Planning Services Sign Permit Review Form

Date of Submittal	Application Number	Applicant	Landowner
11/22/2023	SIGN-044477	Coastal Signs and Graphics	Overhills Community Baptist Church

Reviewed By:	Date of Review	Review Results
Sarah Arbour	12/5/2023	<input type="checkbox"/> Approved <input checked="" type="checkbox"/> Denied

**TekStar Color 16mm 40x140**  
Cabinet Size: 5'x8'  
Sk: 1014517-1-s Cust: 1344468  
6/22/2023 F/bSchmid SOLD  
Scale: 5/8"=1' Cabinet Color: White  
**SIGN DESIGN 301259**

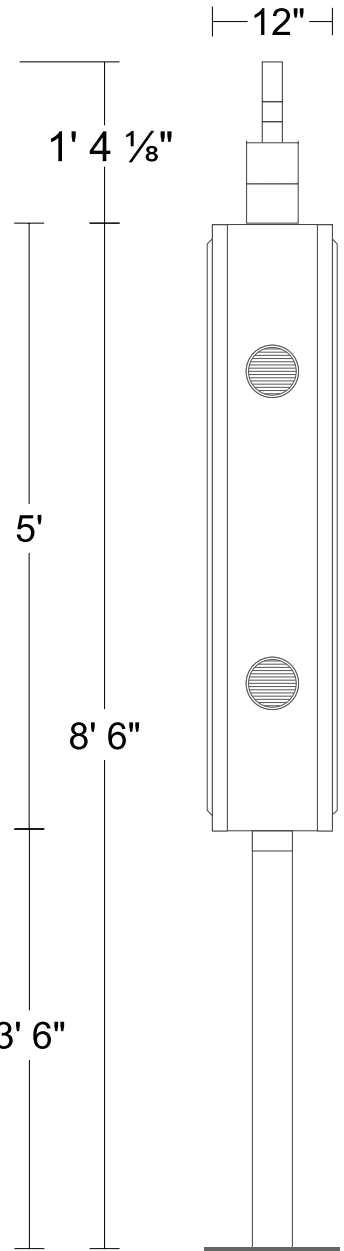
Comments	<p>More information is needed to begin the sign review.</p> <p>1. Please submit a site plan which shows the location of the sign. Please include the distance between the proposed sign and the ROW, side property line, and any other sign located on the property (if applicable).</p> <p>2. Please update the sign rendering with the dimensions of the LED portion of the sign. The maximum permitted square footage of this area is 14 square feet.</p> <p>LED Message Boards are subject to the following regulations. This is provided for informational purposes only.</p> <p>Where illuminated signs are permitted, they shall conform to the following requirements: A. All signs illuminated under the provisions of this section shall be constructed to meet the requirements of the National Electric Code.</p>
----------	--
